17 May 2021

File No: 2021/203545
Our Ref: R/2019/6/C
Your Ref: SSD-10340-Mod-1

Fort Street Public School Redevelopment - SSD 10340 Mod 1 - Design and layout changes

/ Phase 1 - DO/PU Movements

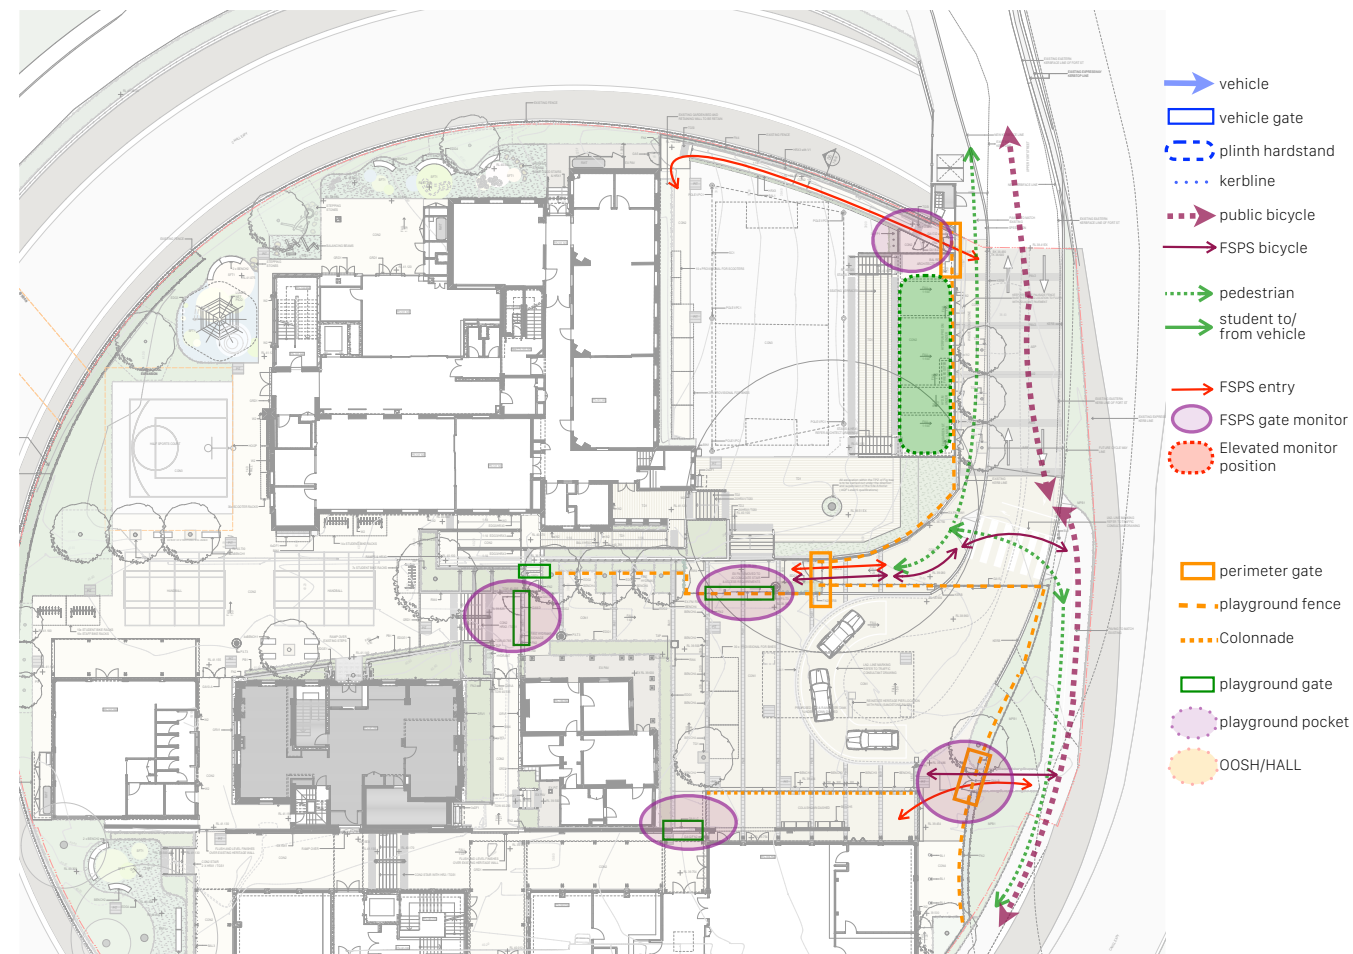
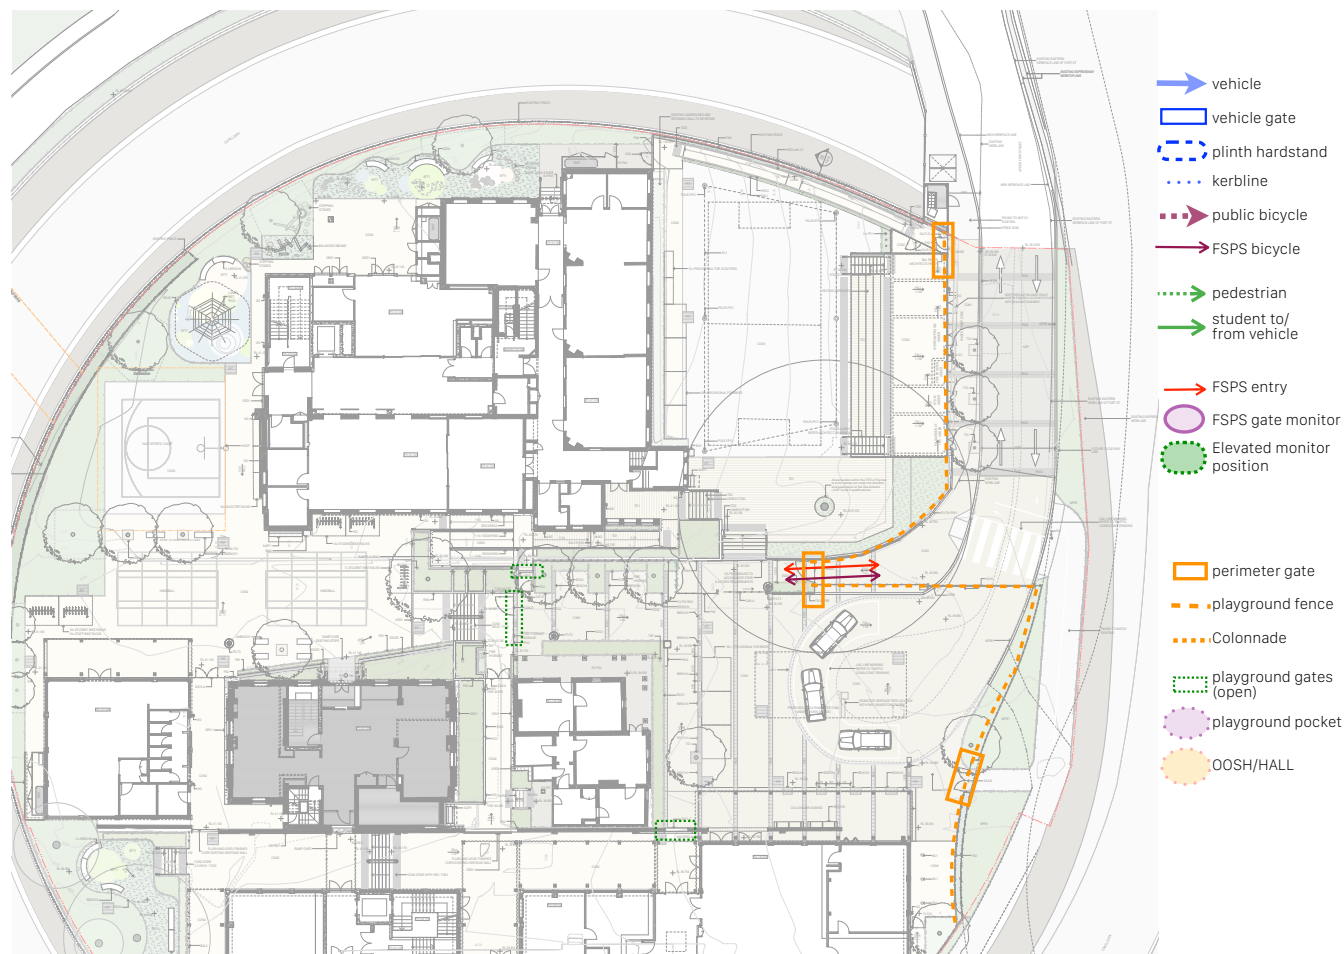
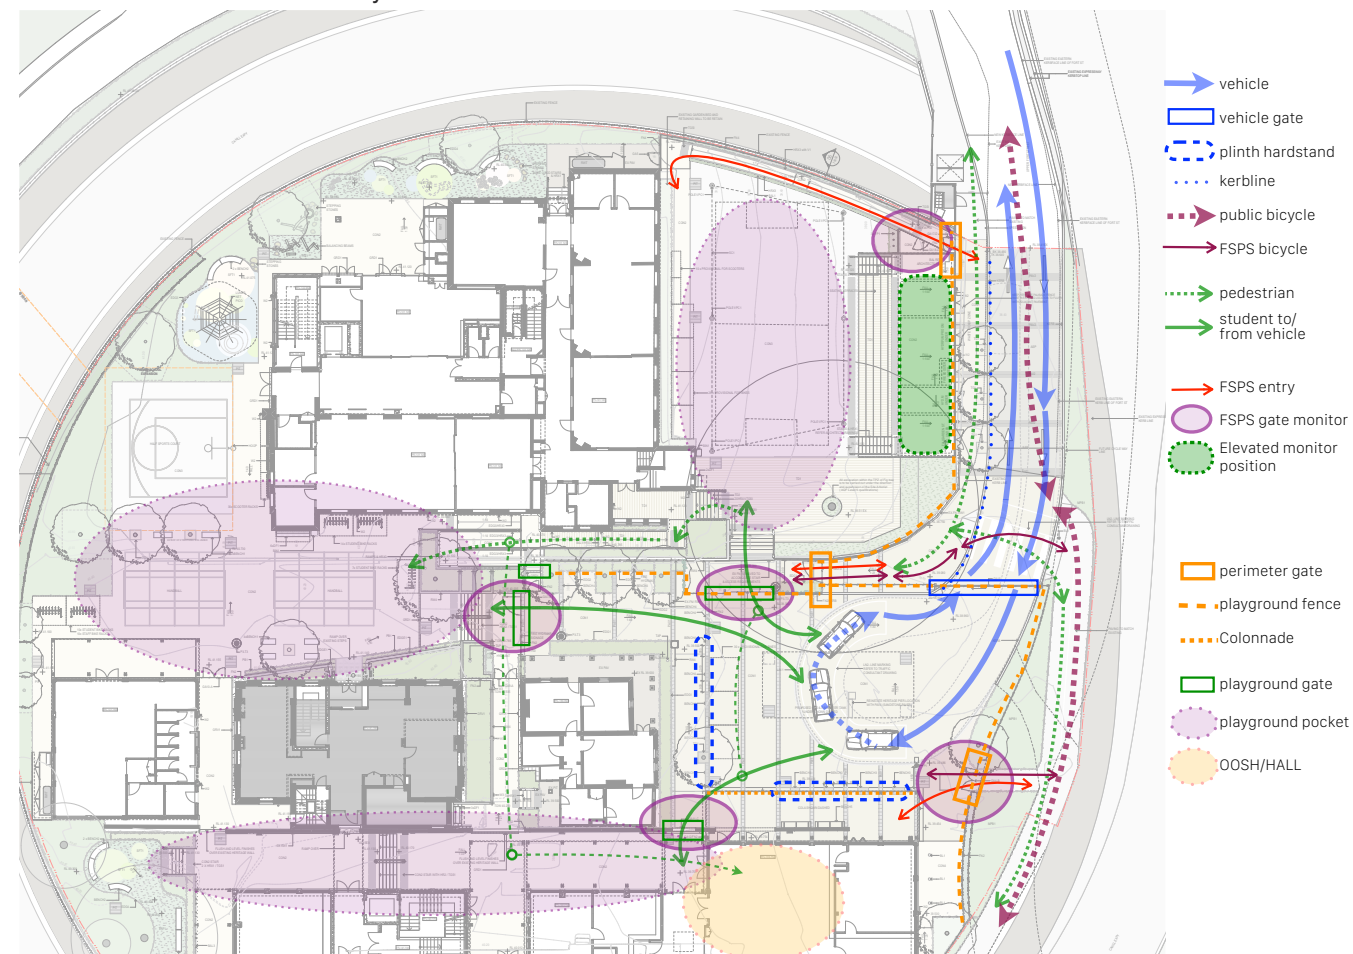
- During Phase 1, there are a lot of cross movements at the proposed pedestrian crossing. The applicant should consider bi-directional cycle crossings on the northern and southern side of the pedestrian crossing.
- During Phase 2, the southern perimeter gate opens directly onto the footpath and cycleway. More space should be provided to allow pedestrians and cyclists access between the school, footpath and cycleway.
- The City notes the proposed turning area of the drop-off/pick-up zone is tight and it is unclear whether there is a physical structure proposed. Confirmation is required that the turning area (drop-off zone) is wide enough for large vehicles (SUVs) to turn.
